Consultation Response: Kirklees Council Conservation & Design (Biodiversity)

<i>Is this a response to an informal consultation request?</i> Yes ☐ No ☒	
Date	<i>14/06/2017</i>
Officer responding	<i>Tom Stephenson</i>
Application number	<i>2017/91677</i>
Purpose	<i>Review of submitted ecological information, pre-determination</i>
Location	<i>Land at, Serpentine Road, Cleckheaton, BD19 3NA</i>

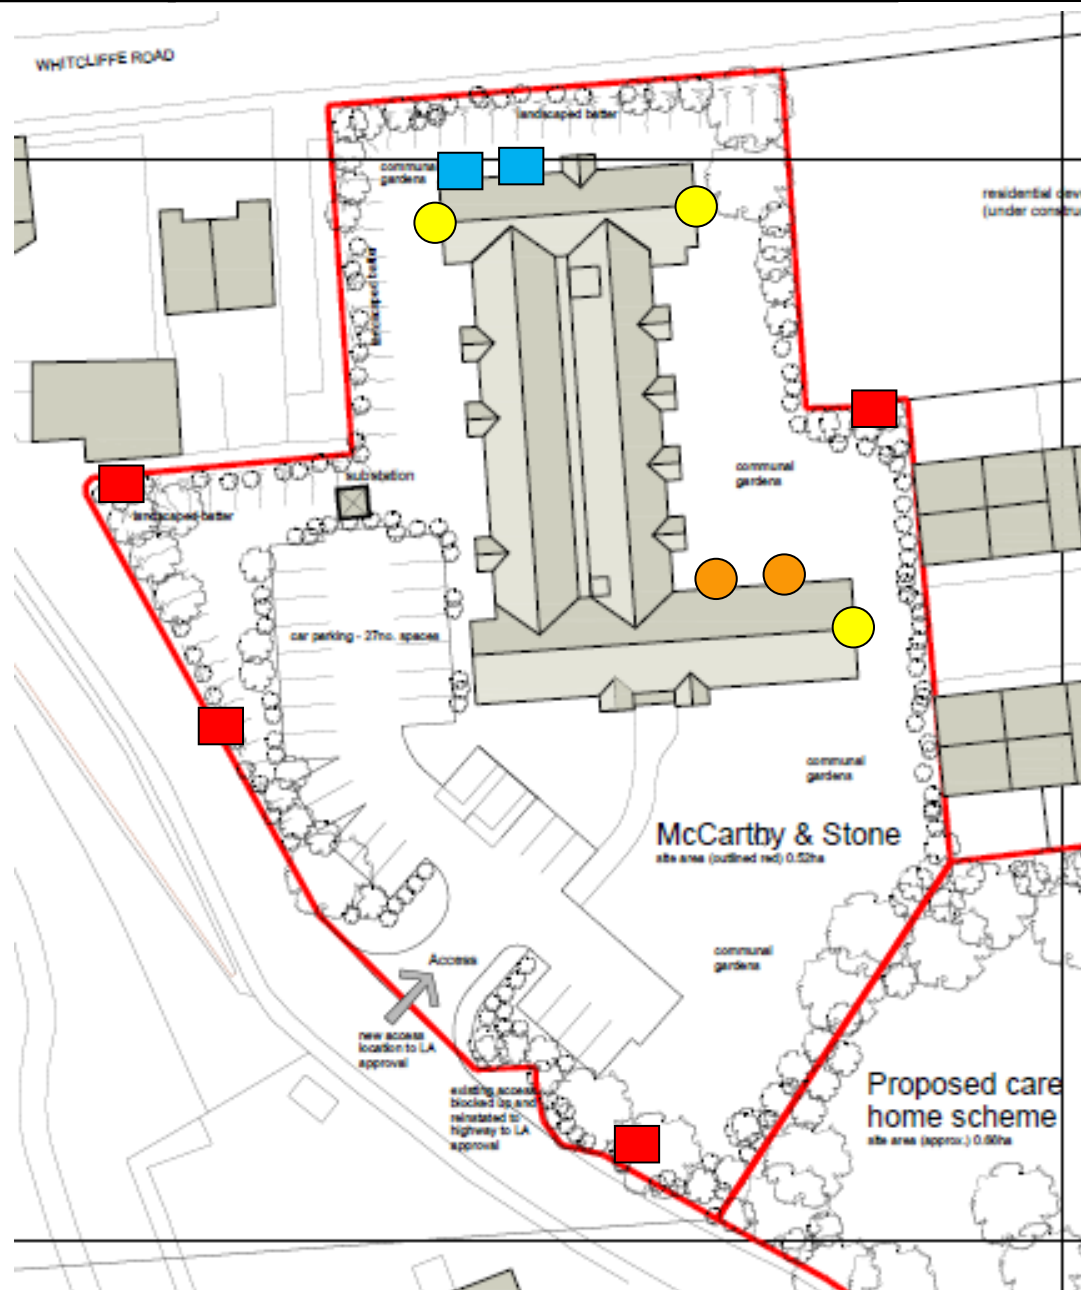
The installation of bat and bird boxes is detailed on the Biodiversity Plan. I support the measures outlined in the Biodiversity Plan in general; however, this only covers the retirement apartments and surrounding landscaped area. This should be extended to cover the whole site.
